# RFS

Your reference: SSD-70748466  
Our reference: DA20250726002963-Response to Submissions-1

**State Significant Development – Response to Submissions – Residential Subdivision/Masterplan  
Response to Submissions - Huntlee New Town - Stage 2 (SSD-70748466), (none)**

- Site Boundary
- Stage 2 Boundary
- Cadastral Boundary
- Parcel Boundary
- Riparian Corridor
- Watercourse
- Asset Protection Zones (PBP 2019)

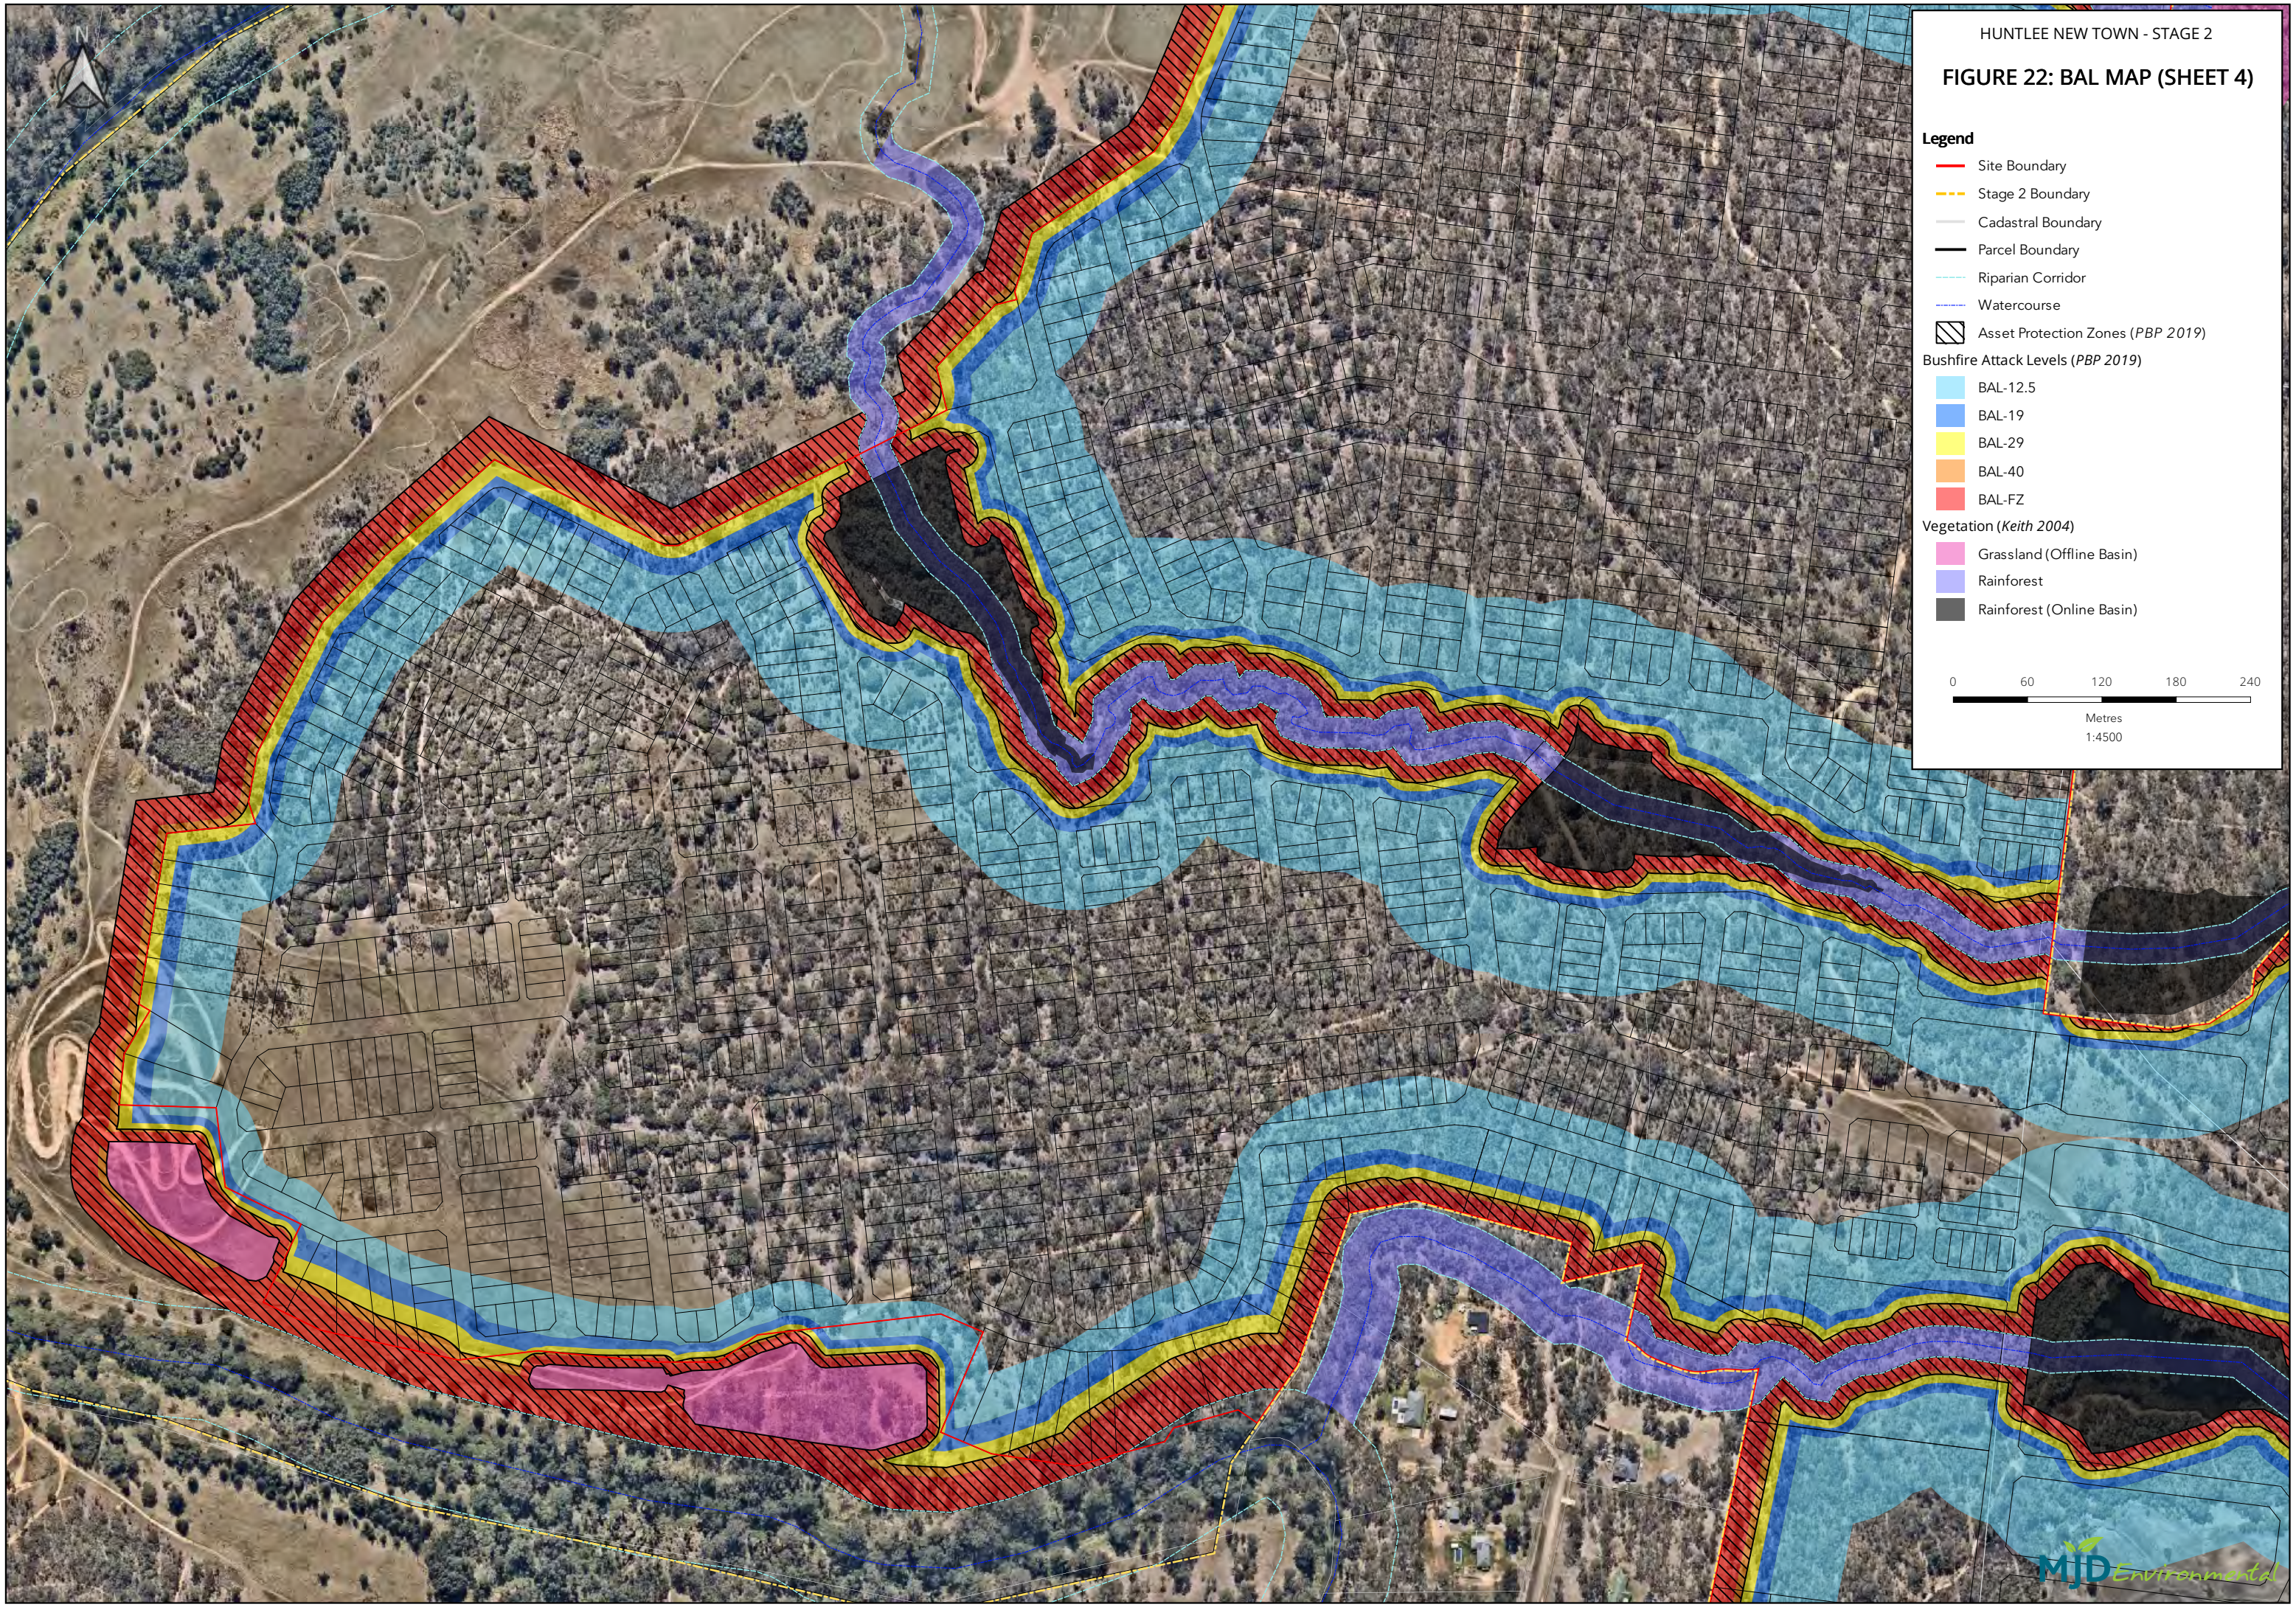
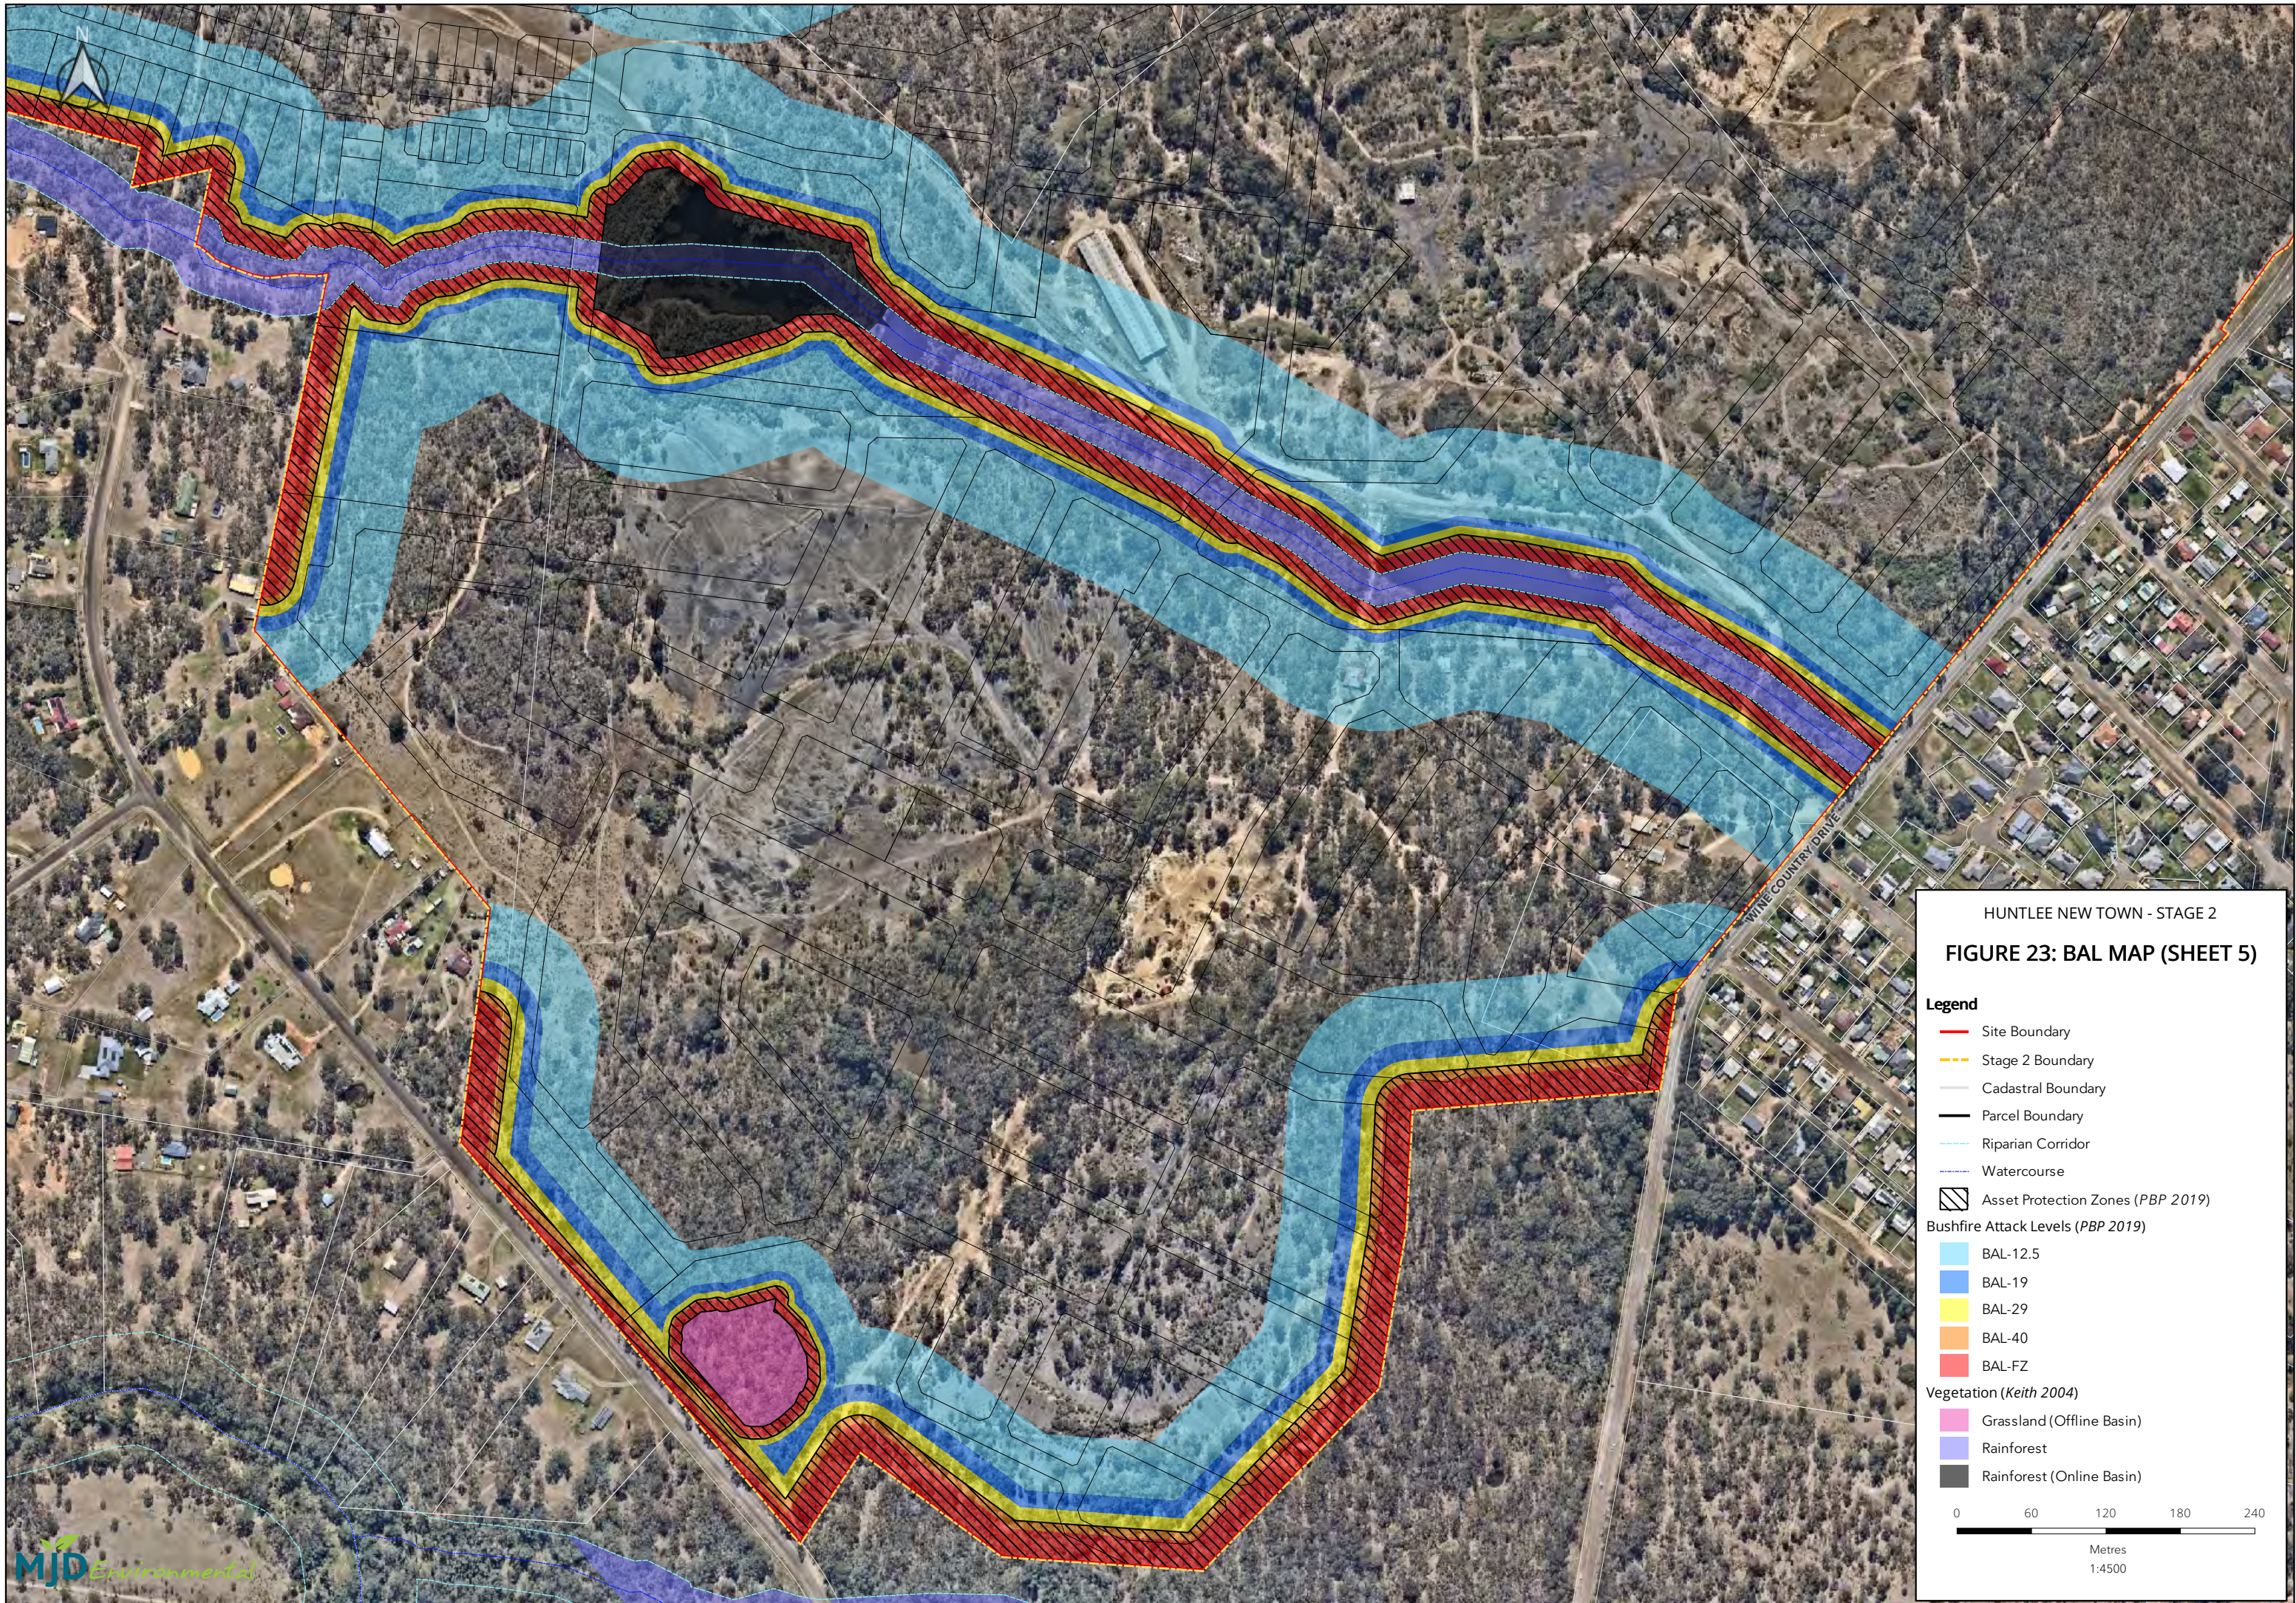
3. A bush fire attack level (BAL) Table must be prepared with regard to the comments above, with a BAL Plan identifying the lot numbers and BAL ratings applicable to future dwellings on lots within the subdivision of Village 2. The BAL Plan provided in Figures 20 to 25 in the bush fire report prepared by MJD Environmental (dated 11/06/2025, V.4, referenced Z:\16015 - Huntlee, Branxton) cannot be relied upon for future development as there is insufficient information provided in relation to establishment of APZs offsite and vegetation management of drainage basins.
